RE: RESPONSE TO SUBMISSIONS - CAMDEN MEDICAL CAMPUS - SSD_7387

Appendix 1

Response to Agency Submissions

Inset E  
1:200

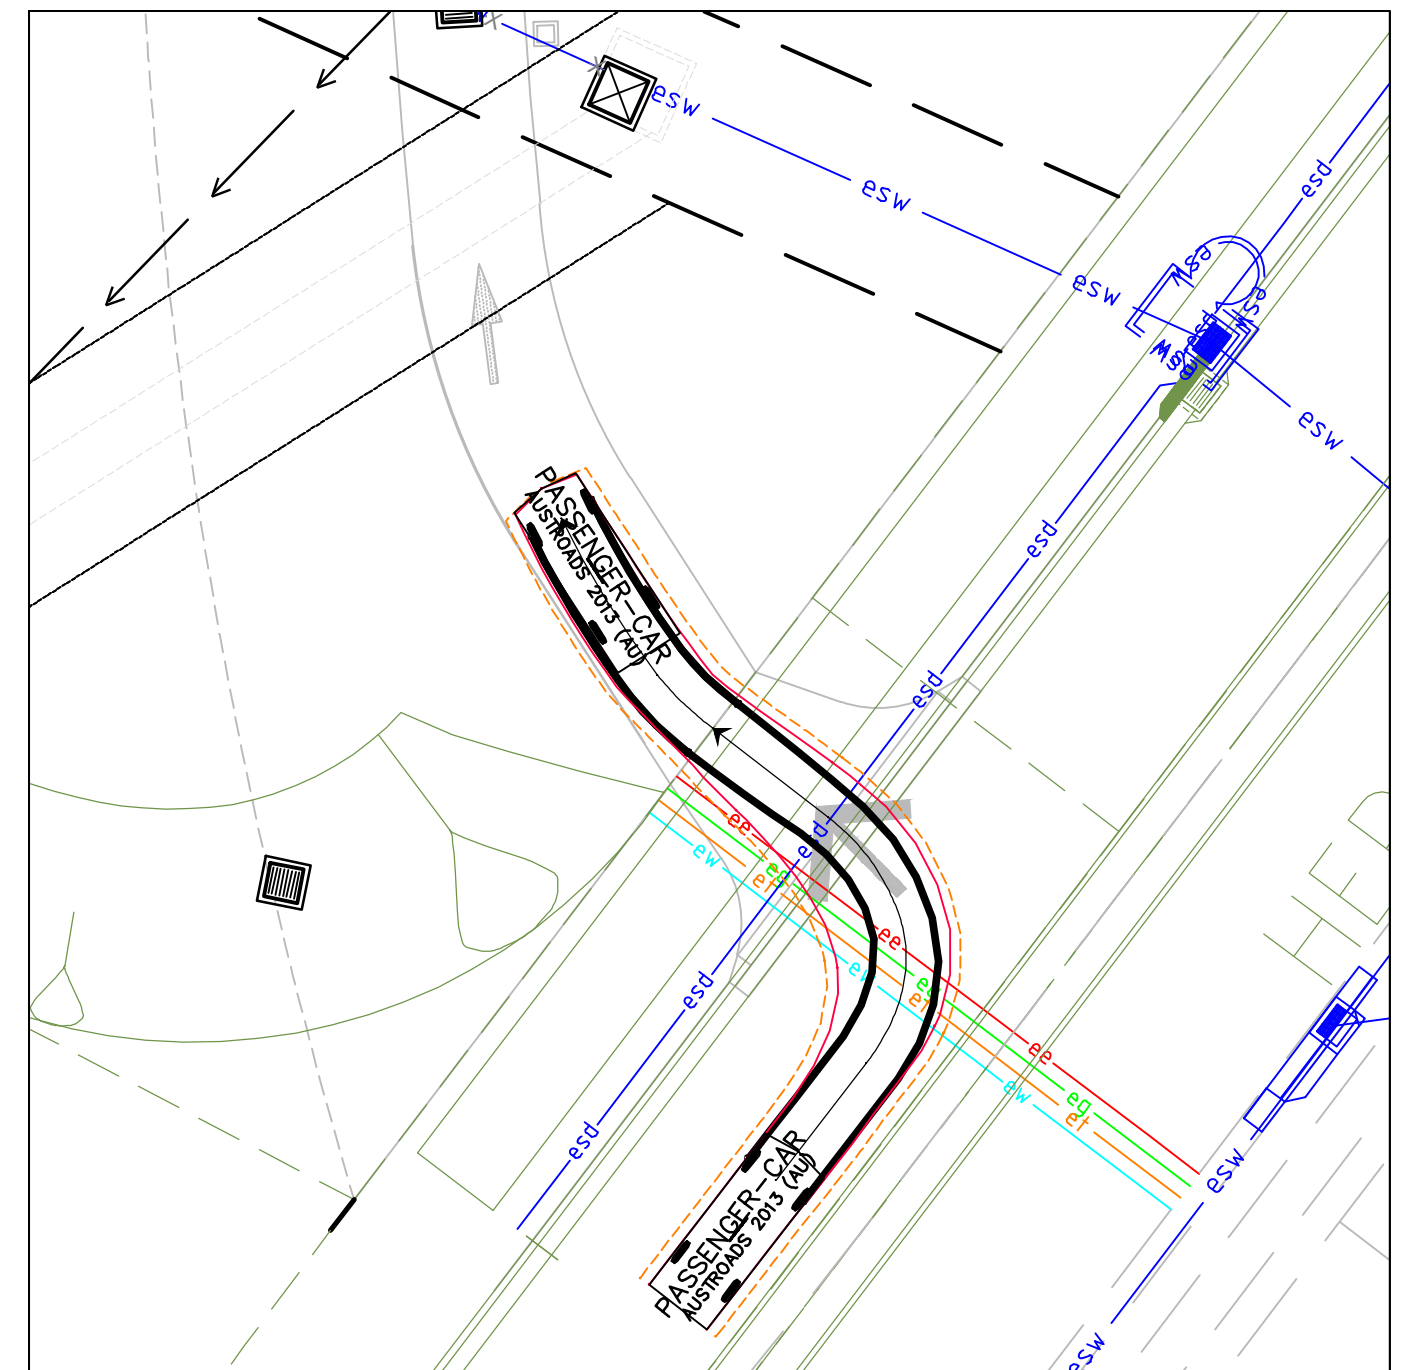
As above	Further details on loading and servicing are required, including how many vehicles are expected per day and the sizes of those vehicles. The detail provided indicates 12.5m vehicles are to service the site. Is this adequate or will larger vehicles be required? No dimensions of any loading bays have been provided. A loading/service management plan should be prepared to ensure vehicles are not waiting on public roads in order to access the site.	<p>The response by Mott MacDonald at Appendix 4 addresses this issue, with an extract provided below:</p> <p><i>"A large number of service bays are proposed and this allows for operational flexibility. The design provision is also noted to be above what is typically provided at similar developments. The turning path analysis confirmed that the allocated loading bay areas within the concept plan are sufficient to accommodate the design service vehicle that has been determined for the site. Refer to section 4.5 and appendix I in the Traffic Impact and Parking Assessment for further information. Further details will be provided as part of future staged planning submissions."</i></p>
